## Goodfire Brewing - 219 Anderson St.

**From:** Christina Stacey [mailto:[cstacey@portlandmaine.gov](mailto:cstacey@portlandmaine.gov)]  
**Sent:** Wednesday, February 22, 2017 10:11 AM  
**To:** Mike Hays <[mike@GRANTHAYS.COM](mailto:mike@GRANTHAYS.COM)>  
**Subject:** Goodfire Brewing - 219 Anderson St.

A-2

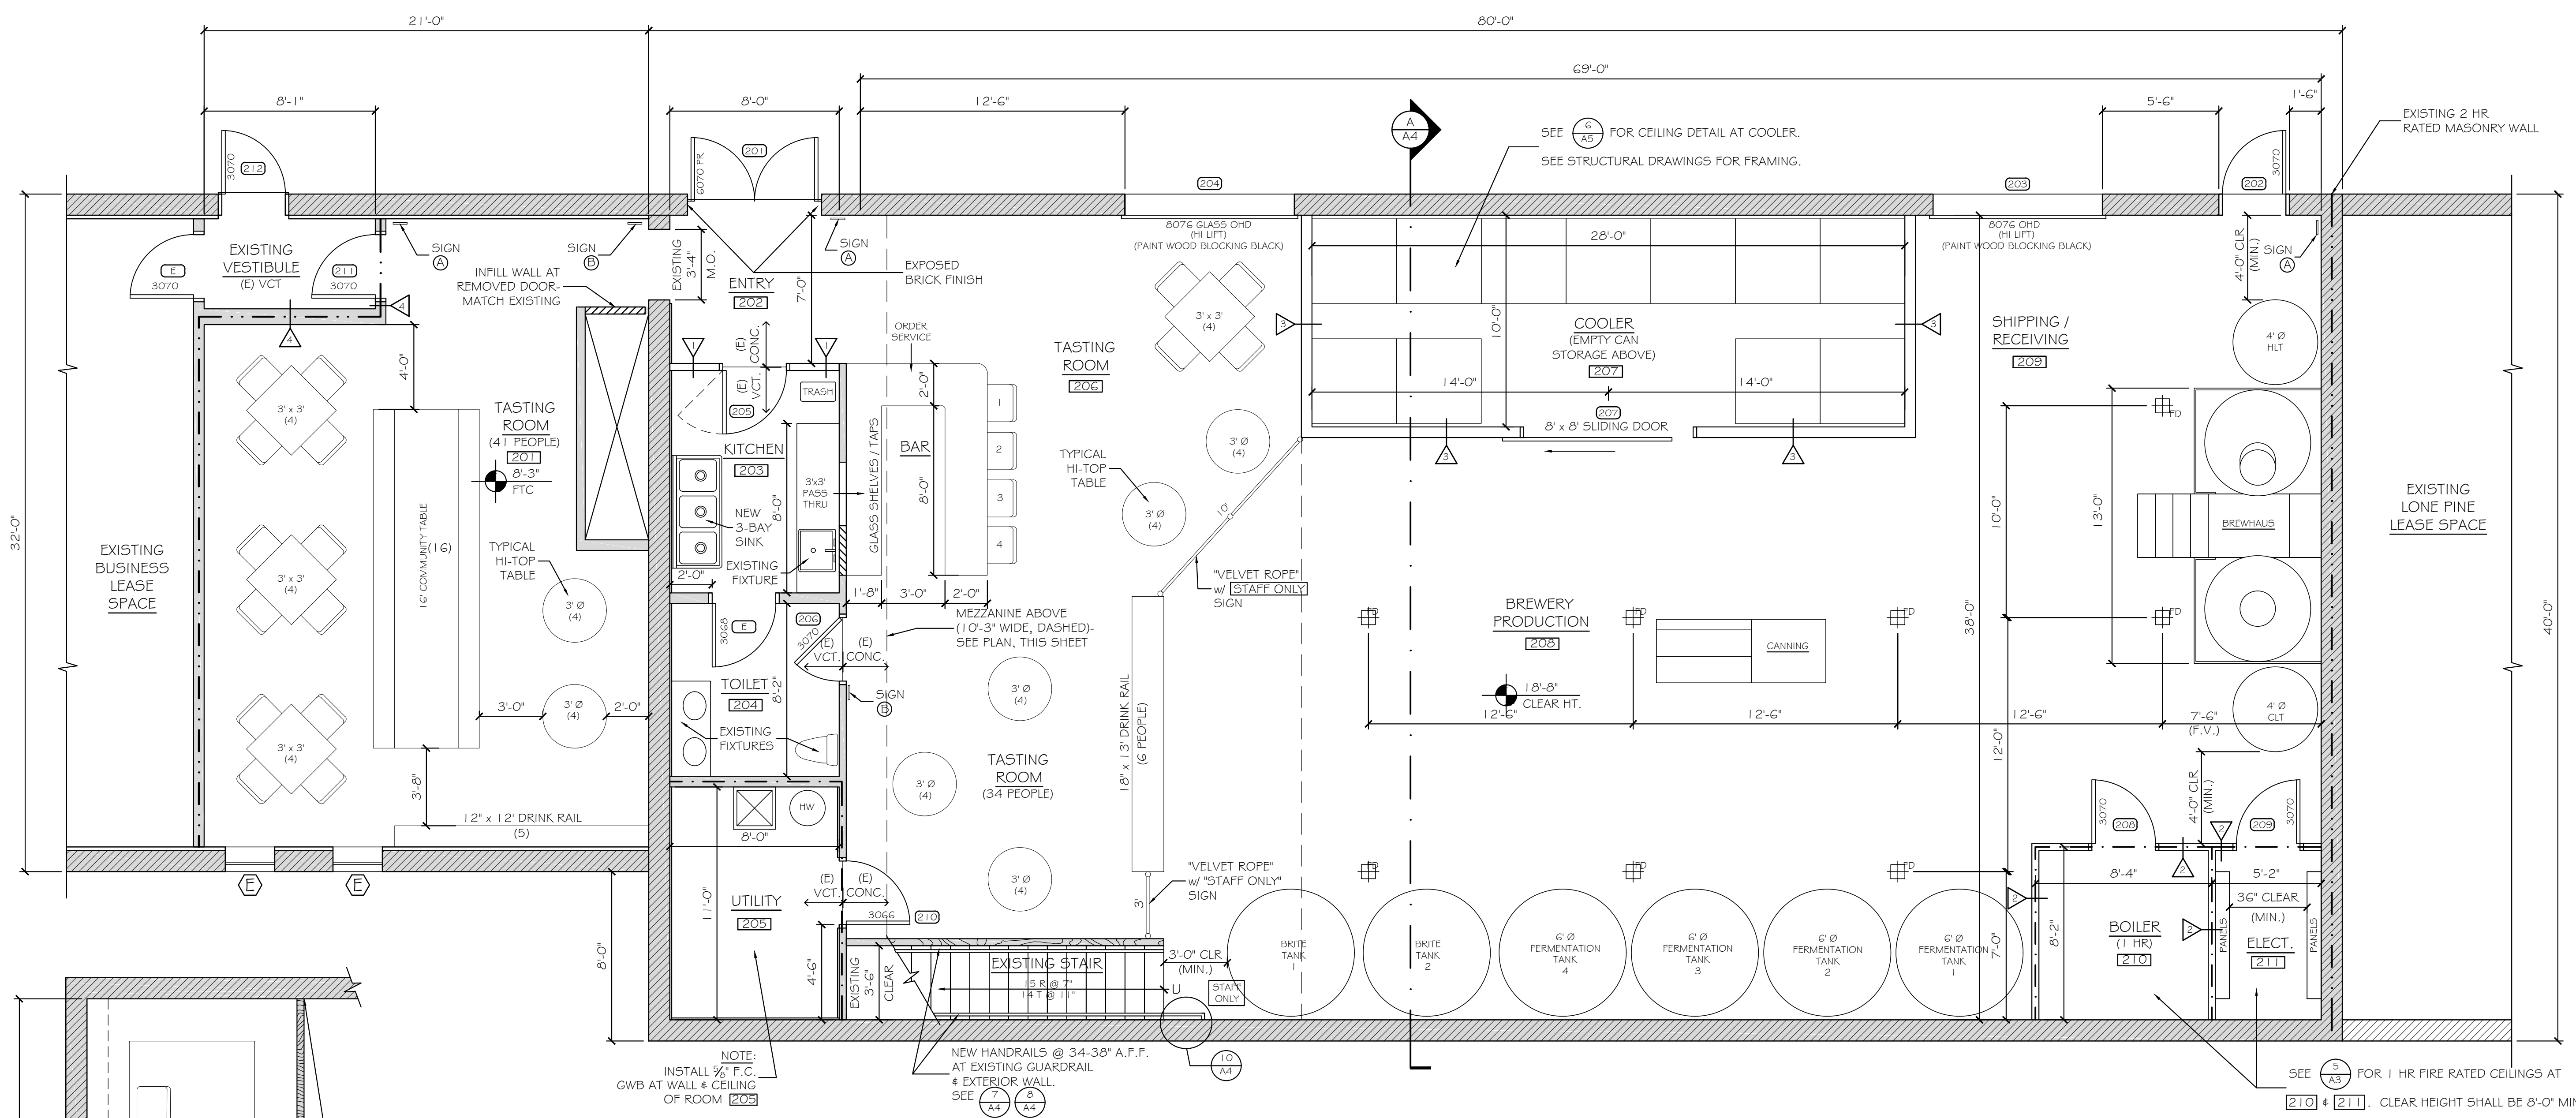
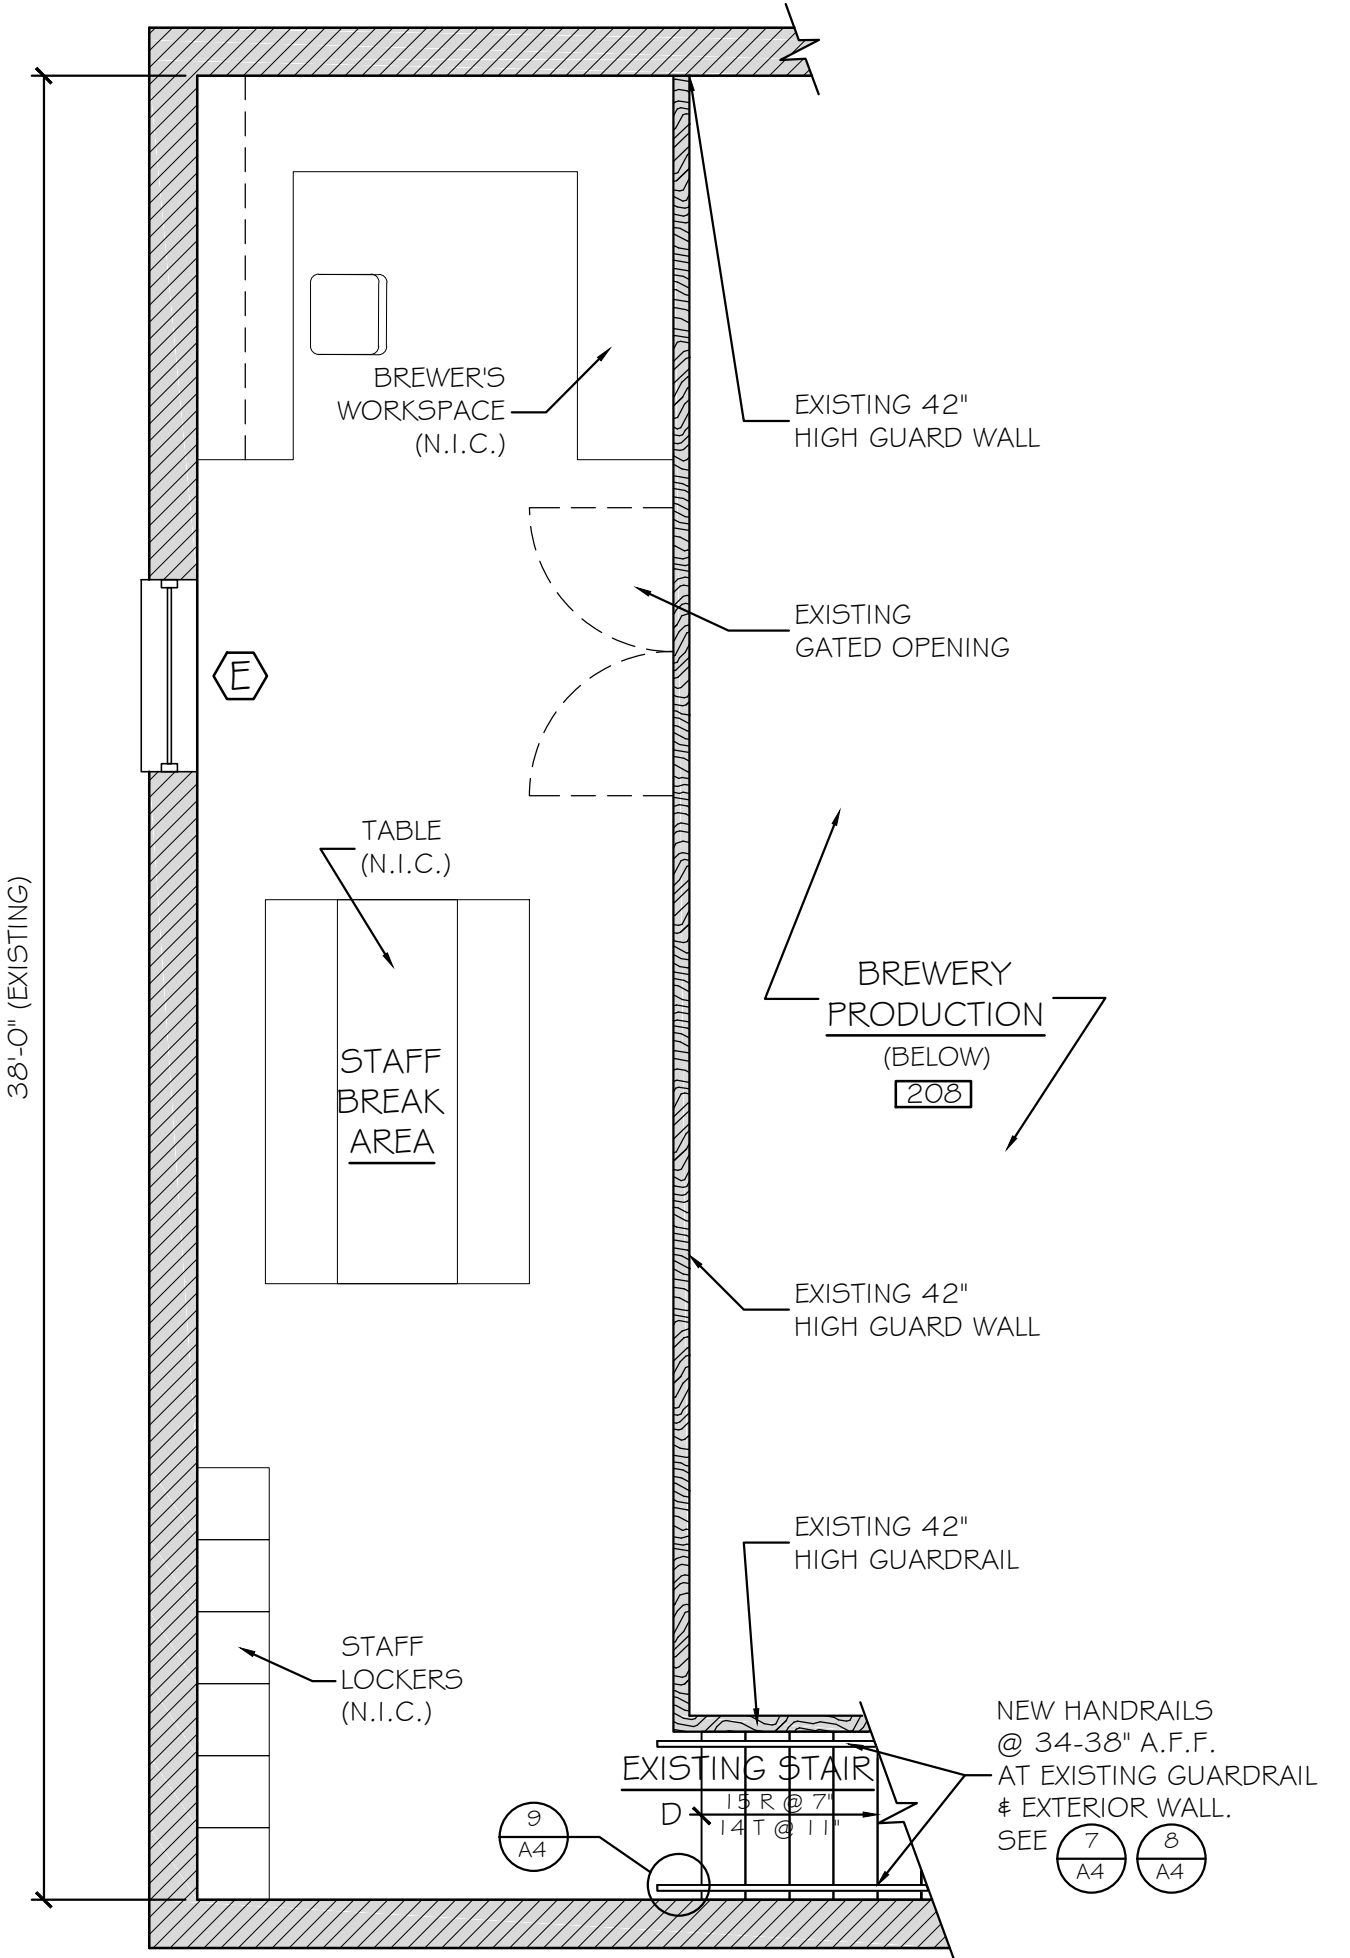
1. I will have the tenant forward a copy of the lease to you directly. His name is David Redding, and he is cc'd on this email. (David – please provide a copy of the lease agreement to Chris per her comment below)
2. The kitchen does not have any commercial cooking appliances in it. There is a hand wash sink (existing) and a new triple sink for glass washing to meet health codes. In hindsight, I should have named this area “Glass Washing”.
3. No food will be prepared on site for the public.
